Your Ref: OWPC26180
Our Ref: AB/20/20/CLP 09-03-2020
Please ask for:
Zac Denton

Lawful development certificate for a proposed extension to existing track across the field
to meet The Causeway at the entrance to the field.

Land to the rear of Queens Lane Arundel

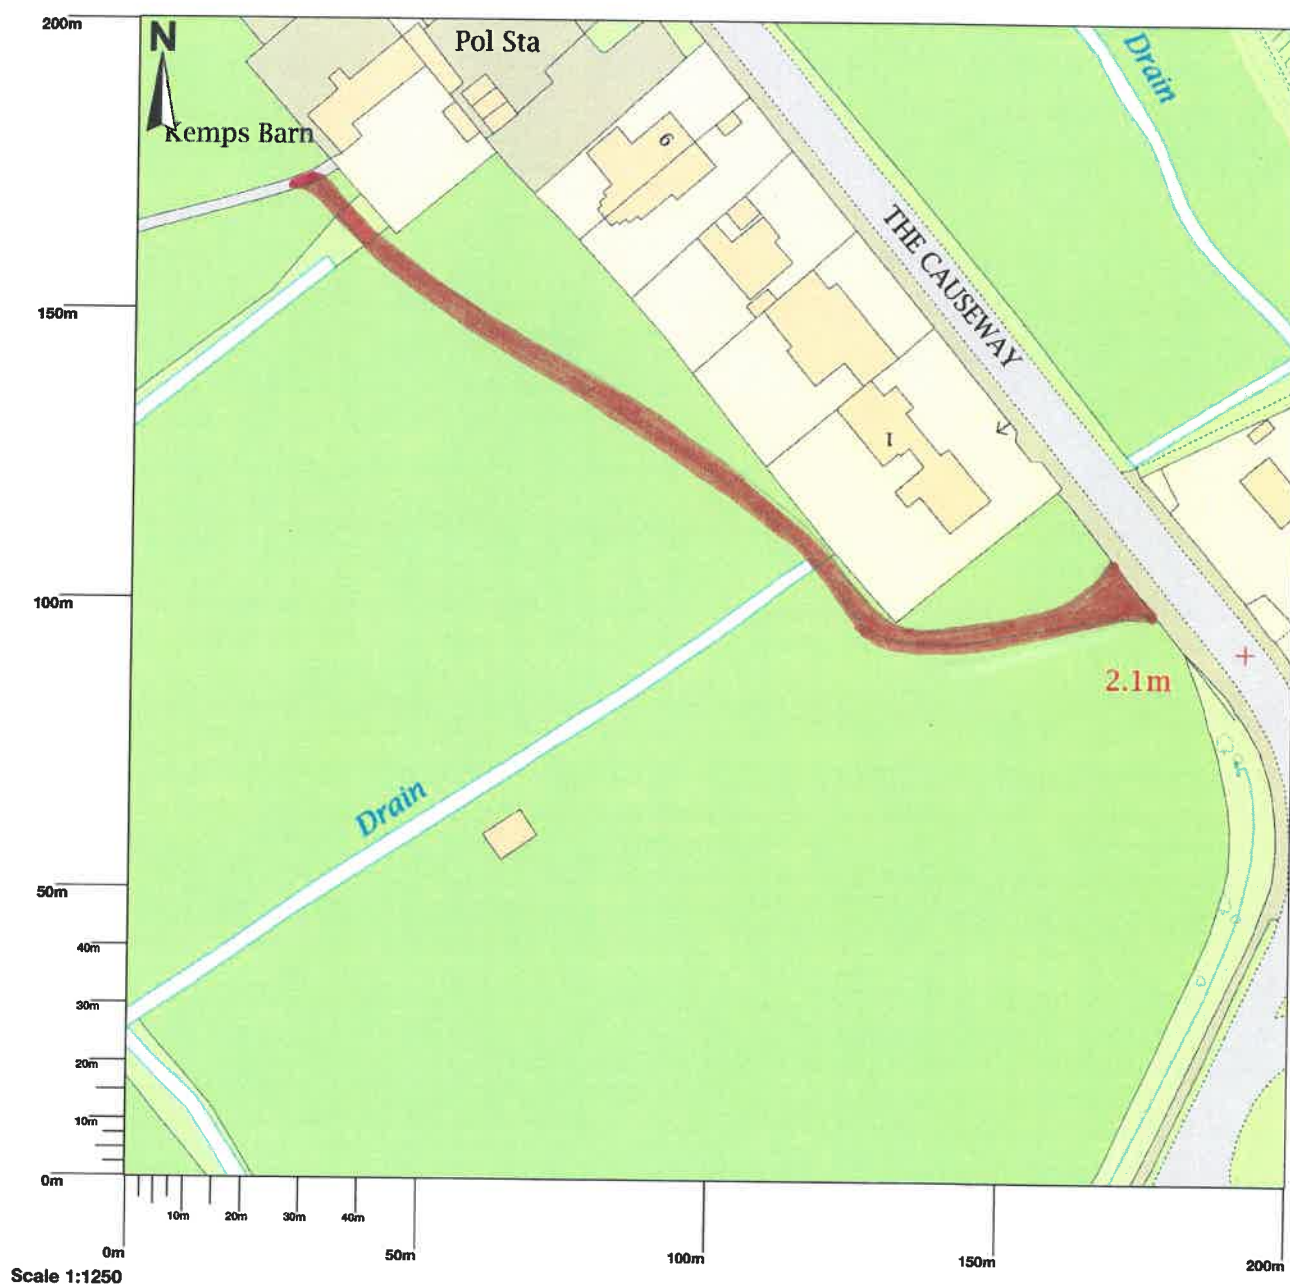
*A few months ago we approached the Harriots for access through the field to our back
garden with a Land Rover. They expressed concern that the bridge over the ditch behind
no.1 The Causeway may not be strong enough and the vehicle would churn up the field.
The location of the proposed track would cause noise and disturbance, a loss of privacy,
pollution and a risk of damage to our garden wall from the vibration of large lorries close
by.*

*A far simpler alternative would be to return the track which extends South West from
Queens Lane to it's original route and provide access to the A27 on a left turn only basis.
Although currently a trunk road a proper Arundel Bypass should be agreed this year and
access to the current temporary relief road should not present a problem.*

*Amendment : the proposed track passed over a rising main, there is risk of fracturing this
and release high pressure sewage.*
